From: Contact Centre (CRM) <contact@ribblevalley.gov.uk>
Sent: 08 December 2025 18:38
To: Planning
Subject: Planning Application Comments - 3/2025/0892 FS-Case-772017815

Planning Application Reference No.: 3/2025/0892

Address of Development: 5 Abbey View
Billington BB7 9NS

Comments: Comments on Application 3/2025/0892
5 Abbey View BB7 9NS

## A106 PROPOSED ELEVATIONS

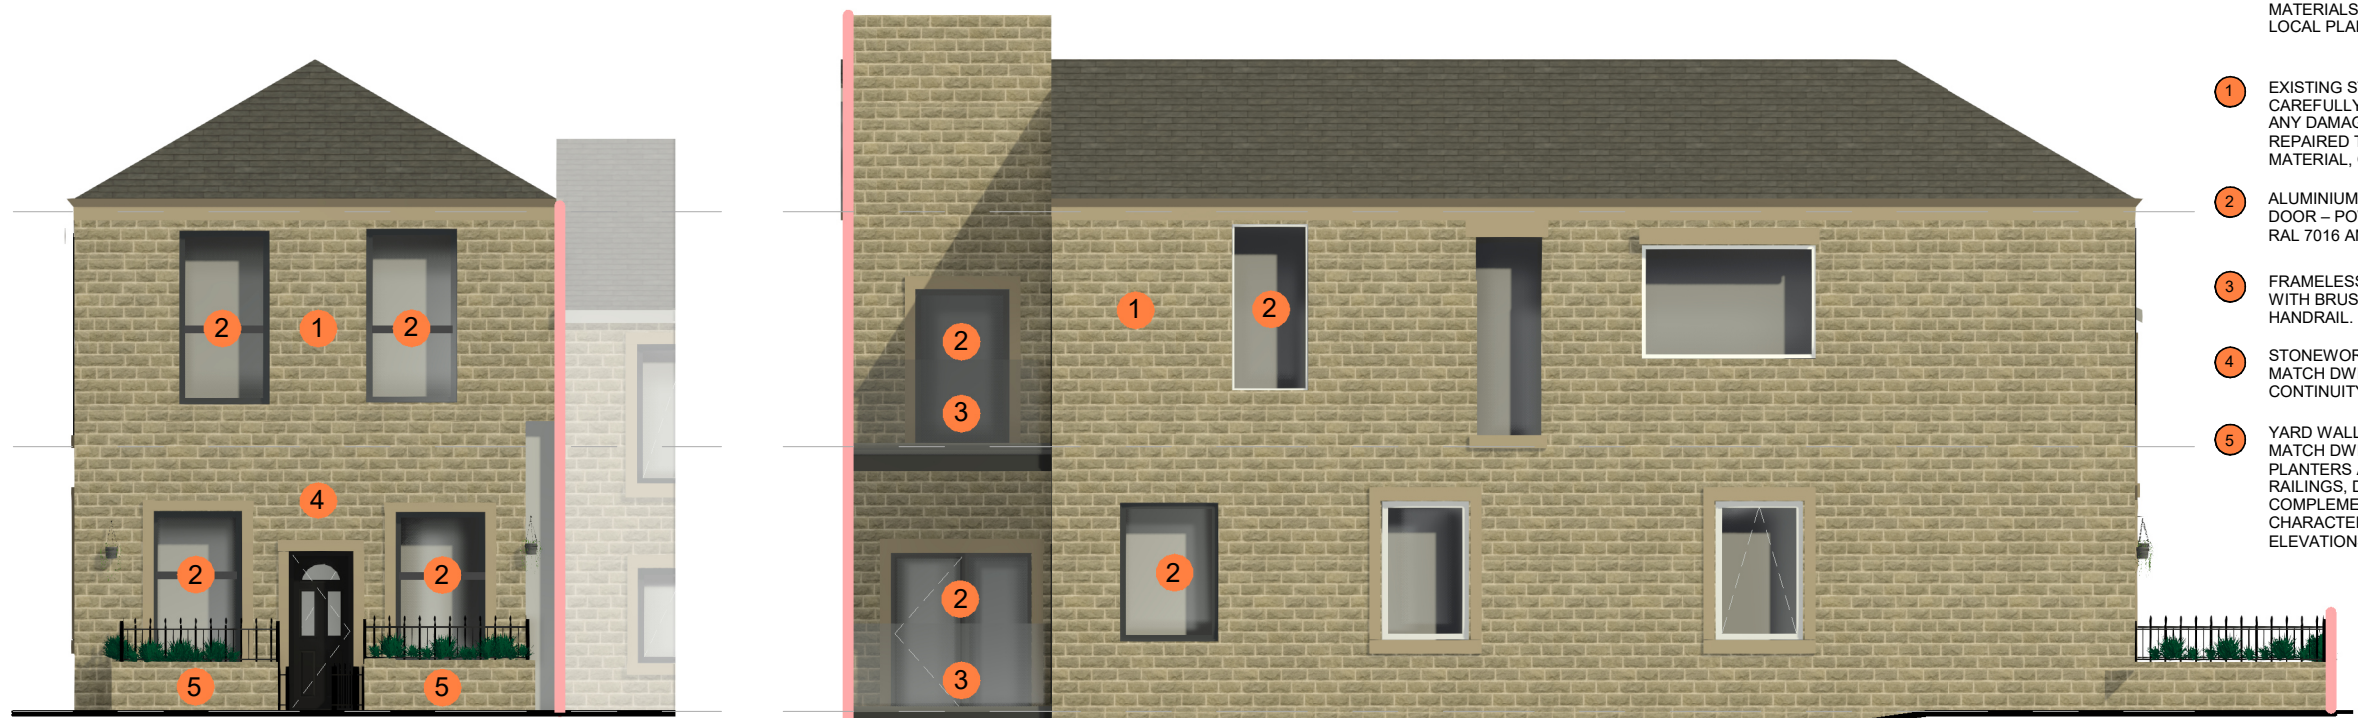
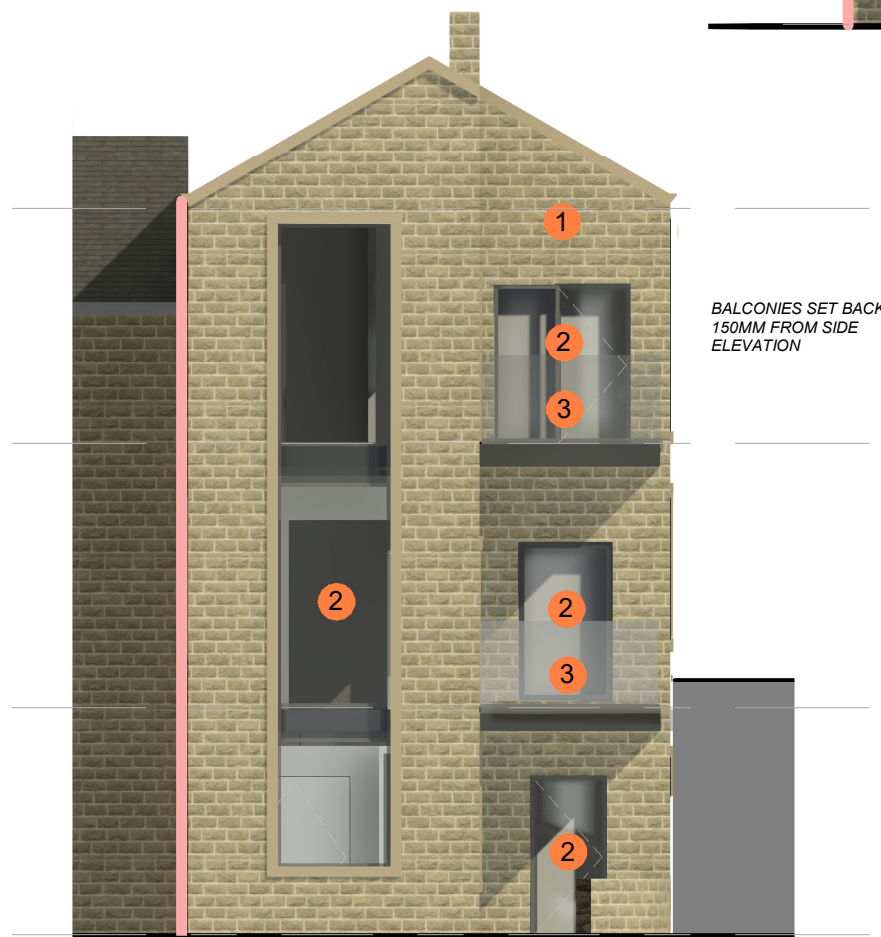
On the proposed elevations (sheet A106) there are significant changes to the rear of the property. On the bottom left elevation there is a large glazed window running down the entire rear elevation and 2 new balconies. These will look out directly onto the shared garden of properties Numbers 1,2,3 and 4 Abbey view. This garden can be seen on the site location plan (A109). The garden occupies the entire rear of the terrace so it would now be overlooked by the large new window and balconies. This would have a negative impact on our privacy and our ability to enjoy the garden.

To the side (bottom right image of A106) there are 2 windows that look over the rear yards of No.s 1,2,3 and 4 Abbey View. One window is currently frosted and the other is on the stairwell of the salon. On the proposed plan (Fig 3 Planning heritage) the stairwell window is being moved rearwards and enlarged. This will mean the new window will have a full and close view into the rear windows of our home. We would request that the windows remain where they are and are frosted to maintain our privacy.

Sheet No.
A105
PROPOSED FLOOR PLANS
Date 03/11/25
Current Revision 7
ISSUED FOR COMMENT

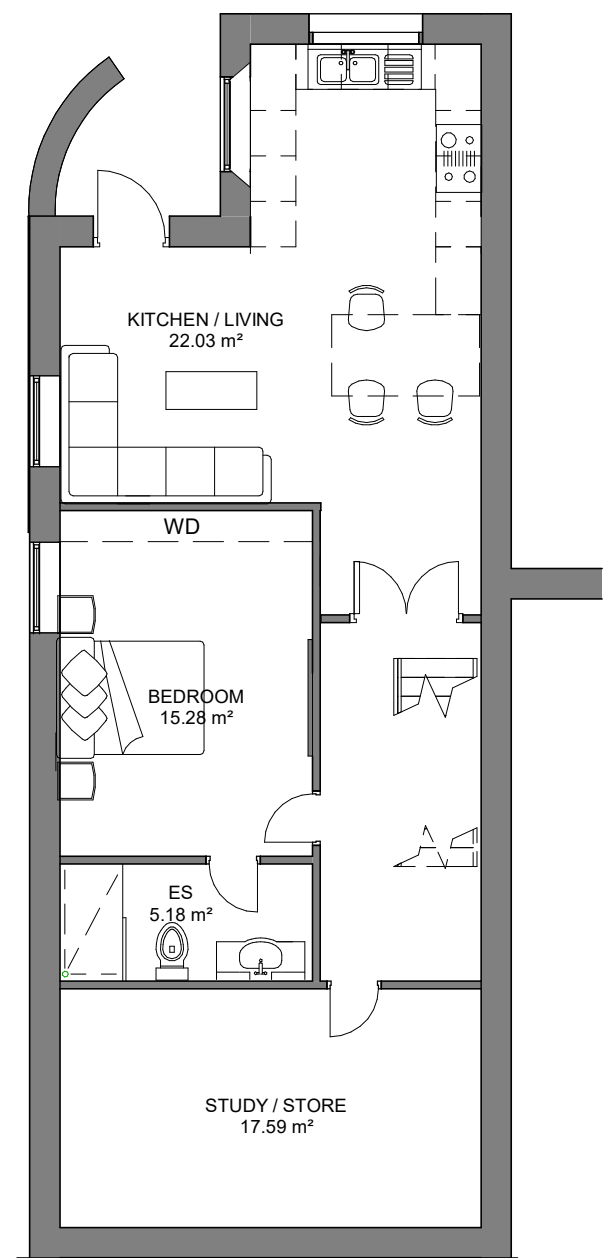
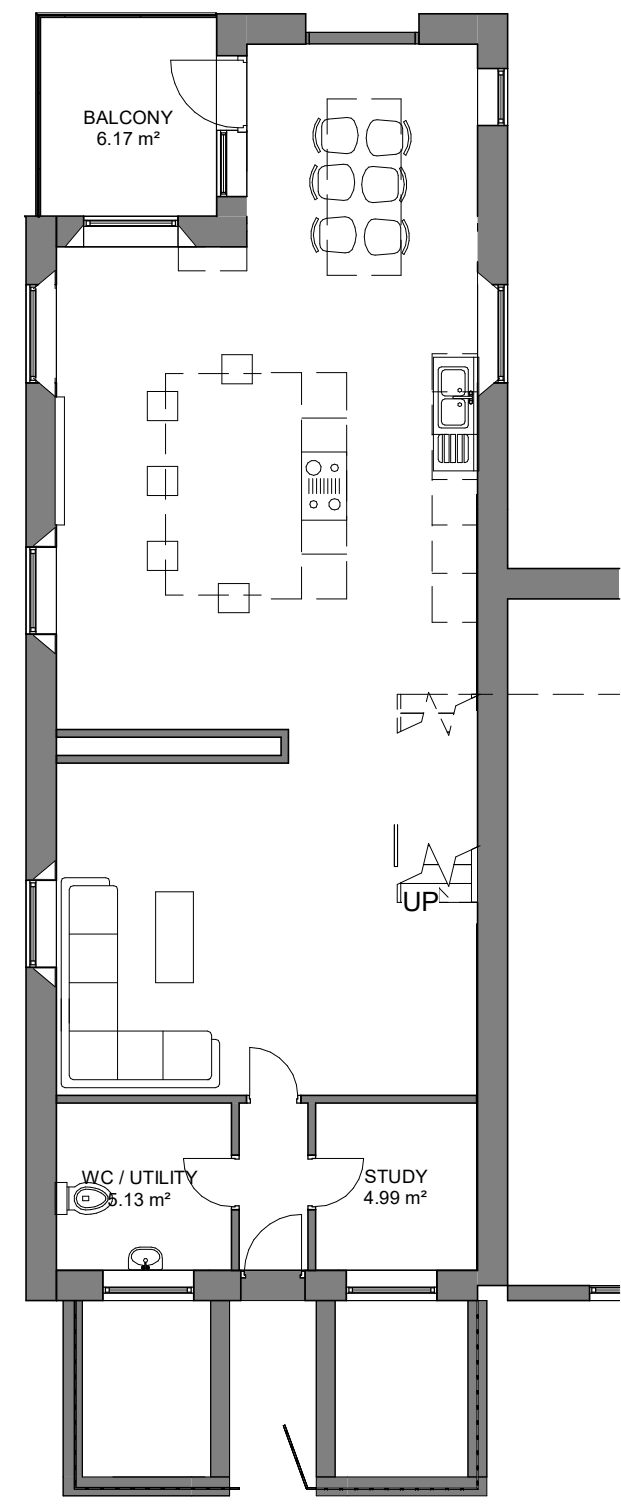
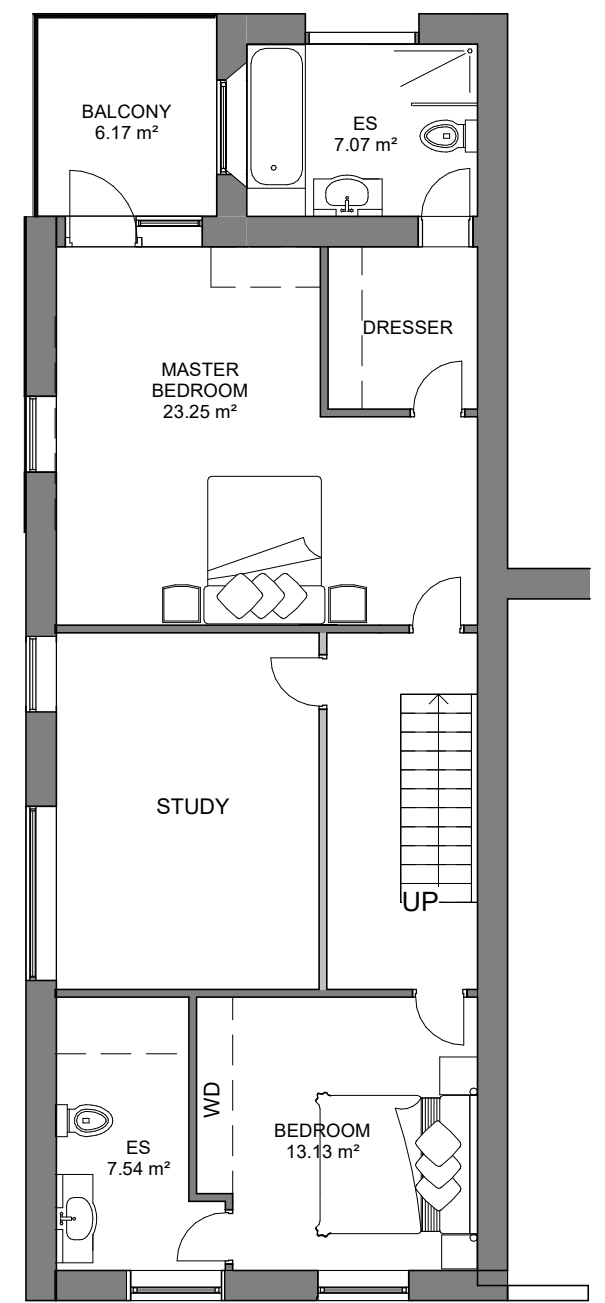
The planning application is for a 3-bed dwelling. The submitted plans appear to show two separate residential units with plans for 2 kitchens on separate floors and 2 separate access points. We have a concern that this is for a flat and it raises the possibility that the plans are for a flat plus Airbnb. This would be a big issue for [REDACTED] and our neighbours. With the uncertainty this creates about the actual proposed development we would want clarification and revised plans before any planning decision is made.
